MEMORANDUM

TO: Jean Fraser, Planner
FROM: David Senus, P.E.
DATE: September 6, 2013
RE: 133 York Street – 6 Unit Residential Building, Level III Site Plan; Response to Comments

C1.2

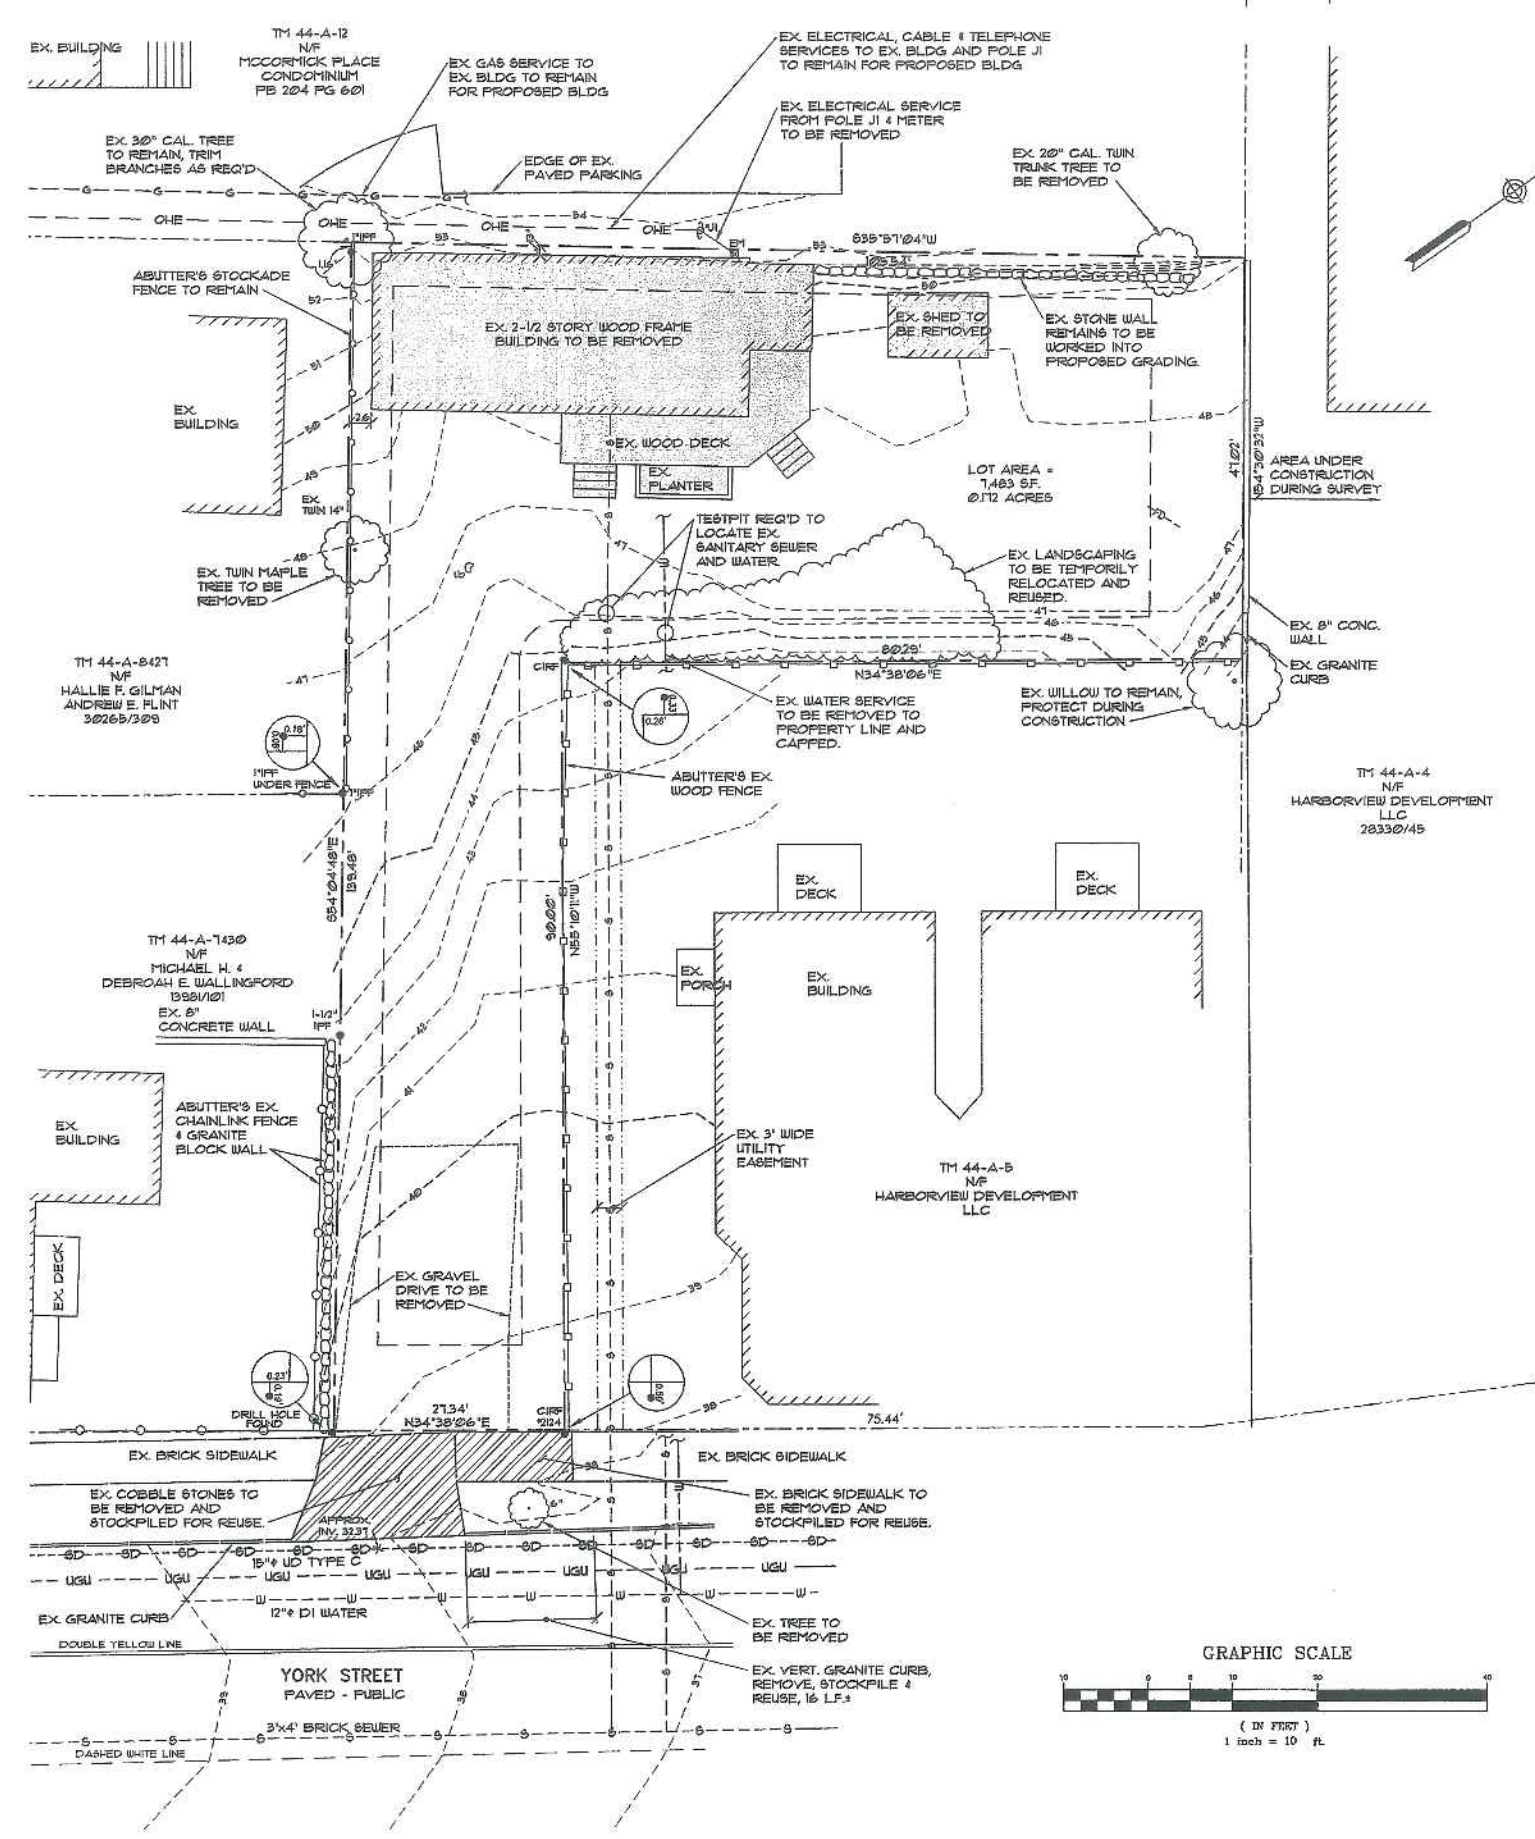
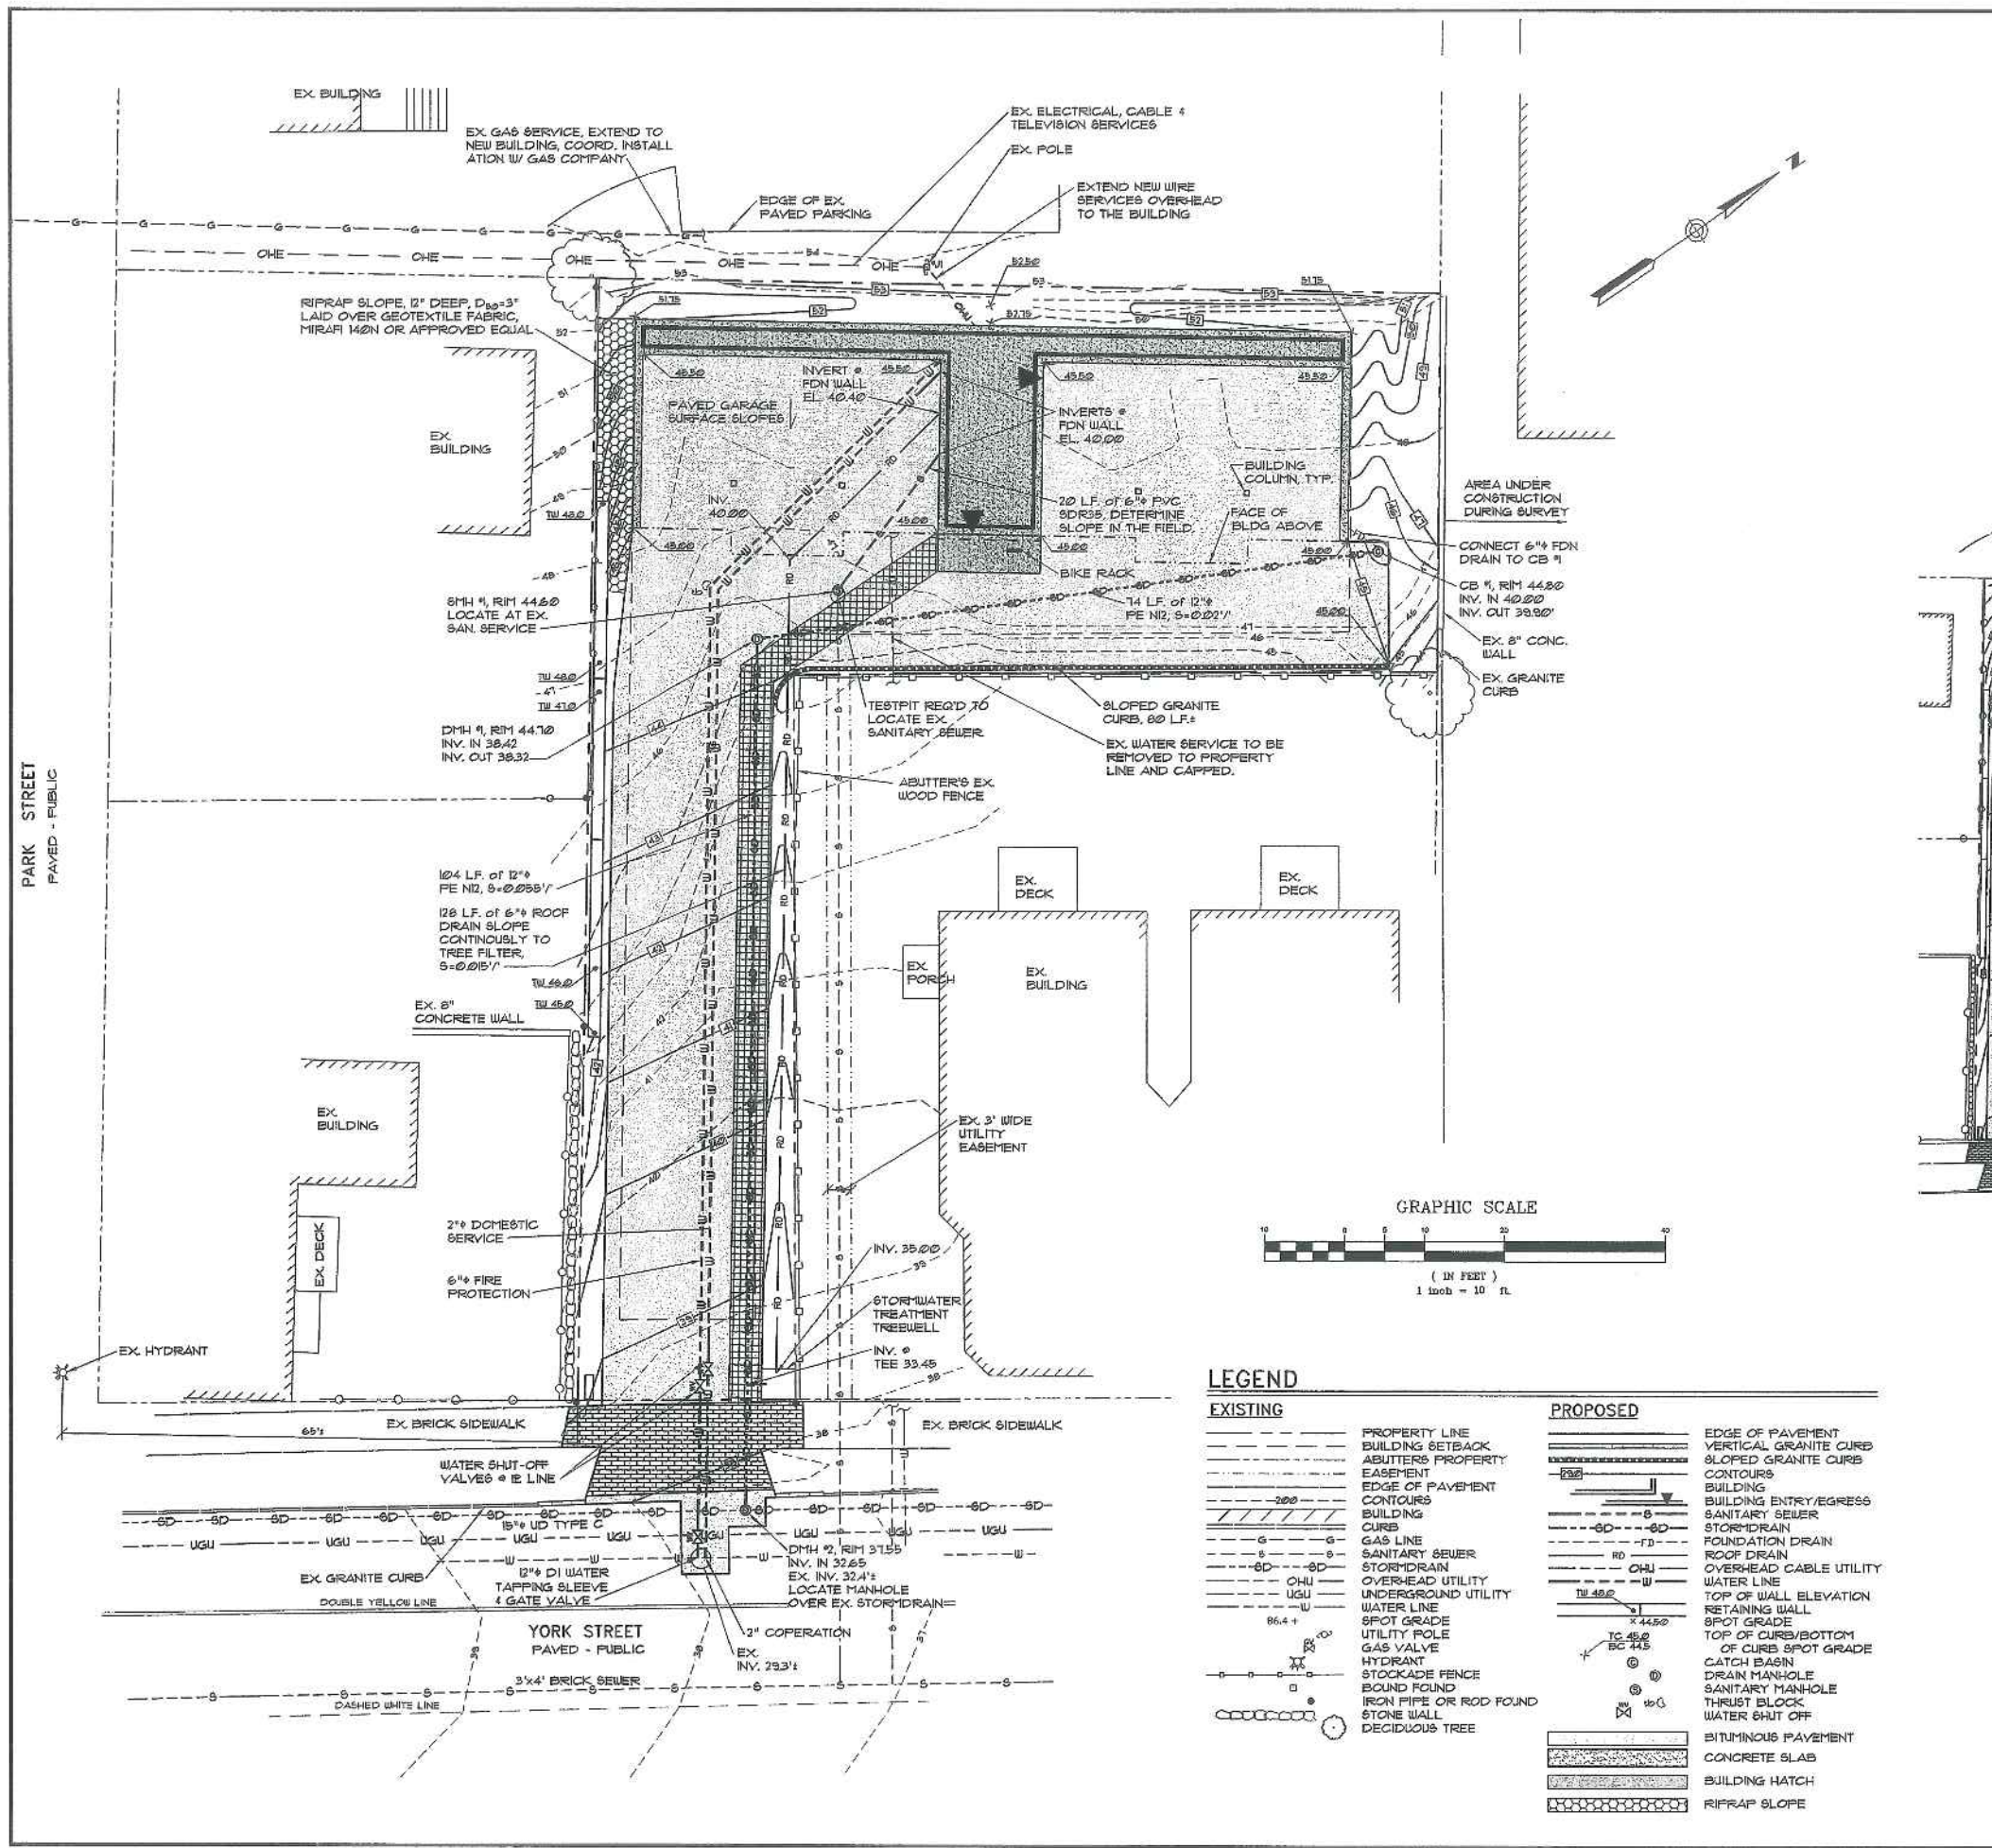
- 1) Basic General and Flooding Standards:
 - a. Comment adequately addressed.
 - b. Please provide design calculations or verification from the manufacturer confirming that the 4x6 tree filter unit, as proposed, is sized and designed to accommodate the water quality storm event for the contributing land area.
